CUMBERLAND COUNTRY GOLF CLUB

Response to DPHI Submission – Summary of Changes

SCALE	DATE	DRAWN	CHECKED
1:1000 @A1	15/11/2024	SM	MS
1:2000 @A3			REVISION
JOB	DRAWING		C
20082	DA7.03

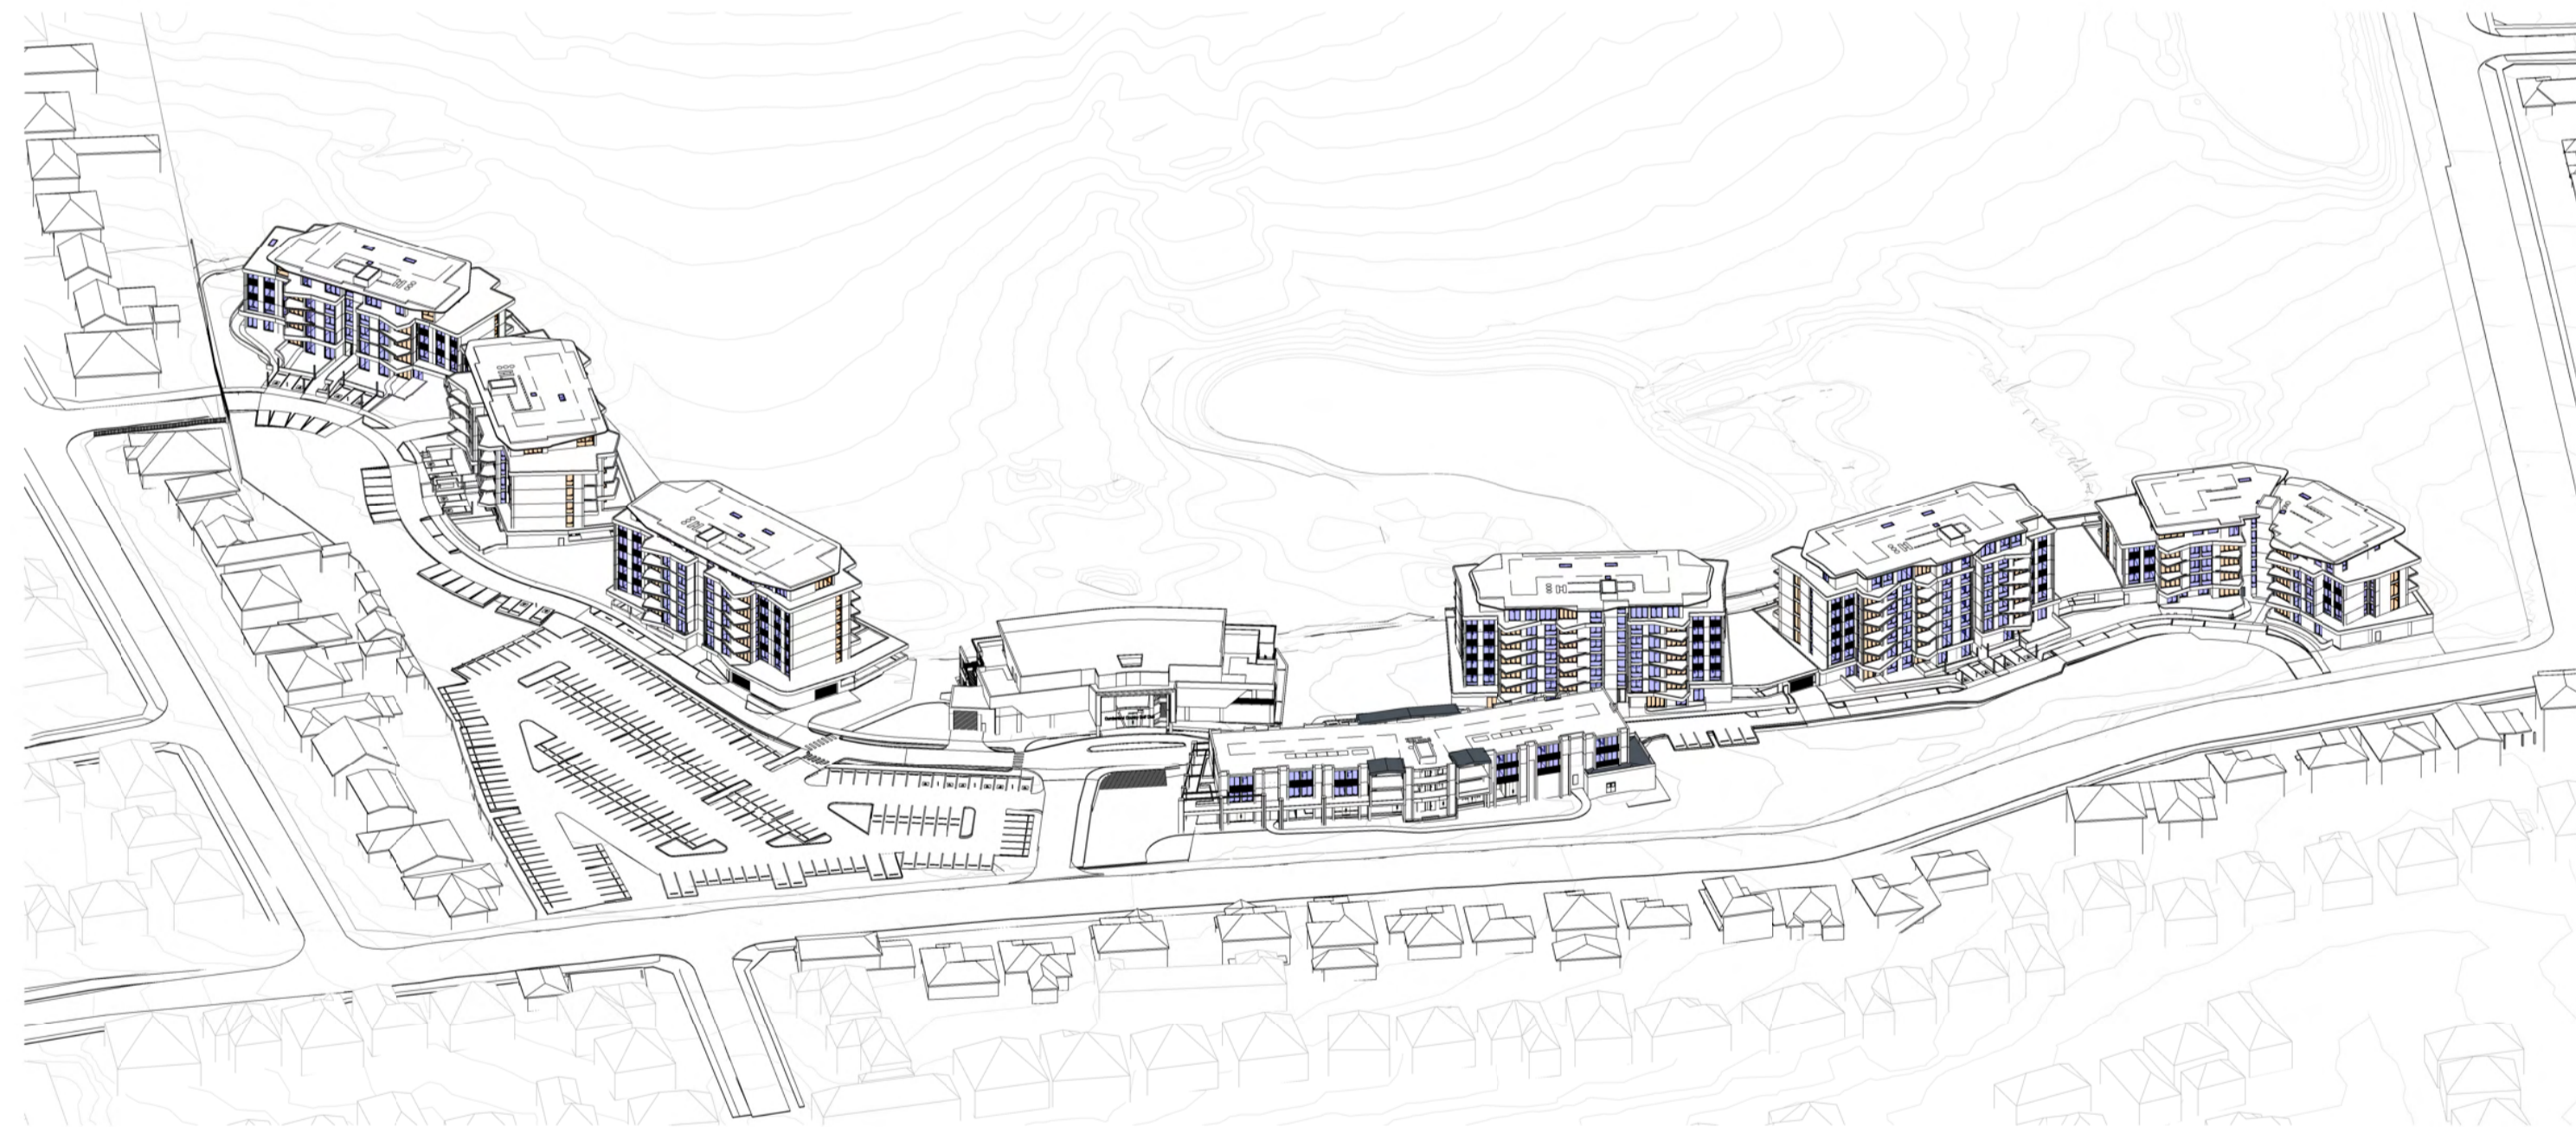
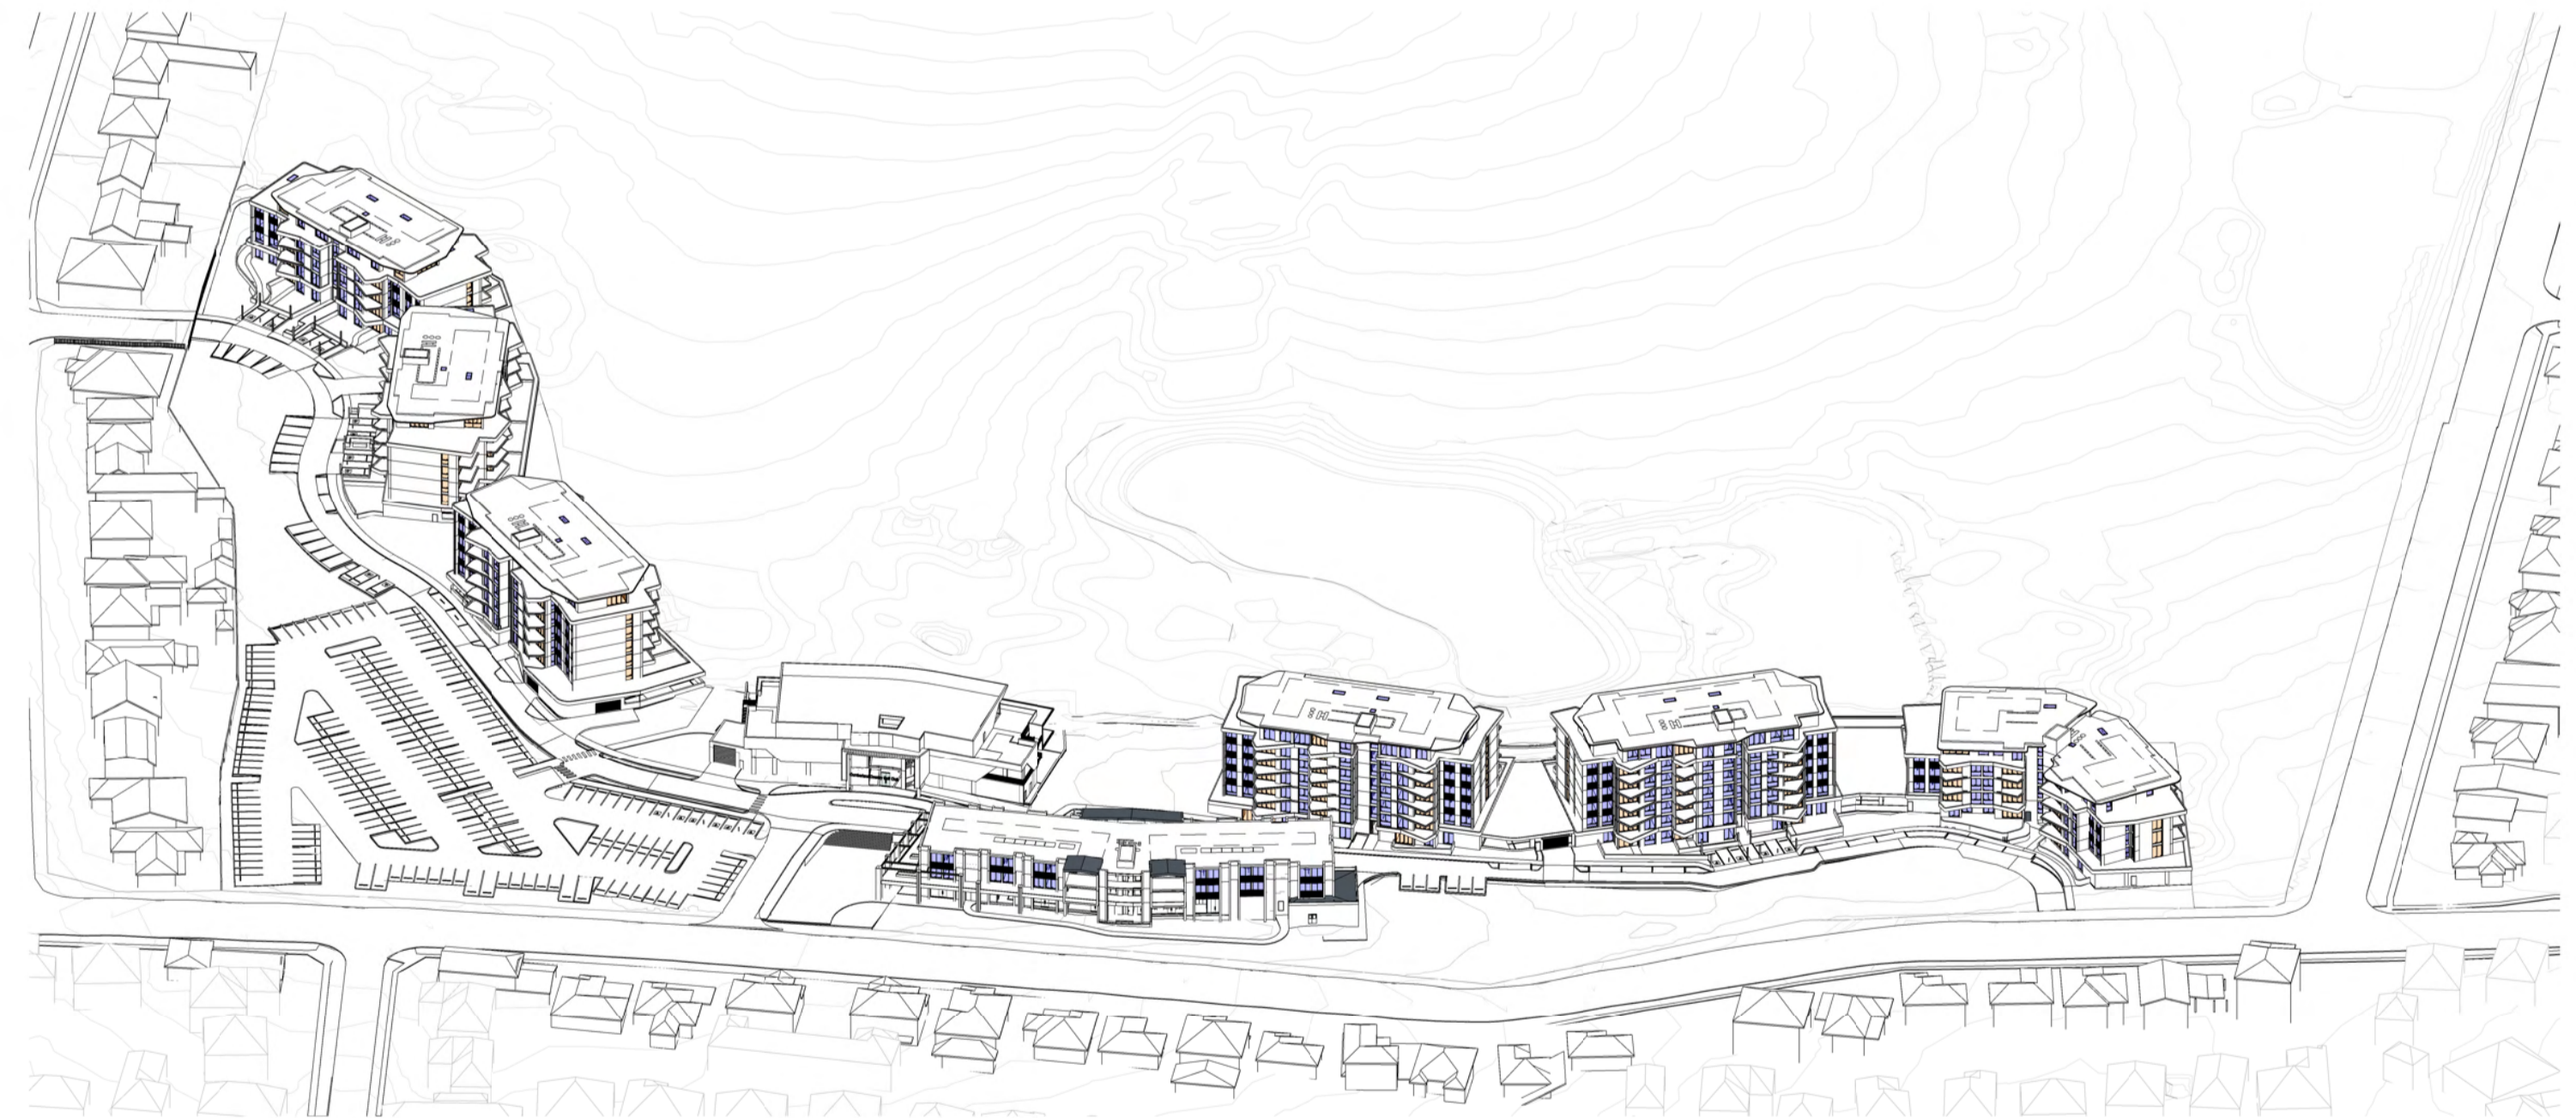
- 9- Shadow Diagrams: Drawings DA7.01 to DA7.03 have been amended to show shadows coloured by building. DA7.03 shows a detailed area of Buildings E and F shadows from 13:00 to 15:00, noting the encroachment area of the shadows into the private open space of neighbouring properties by hour.
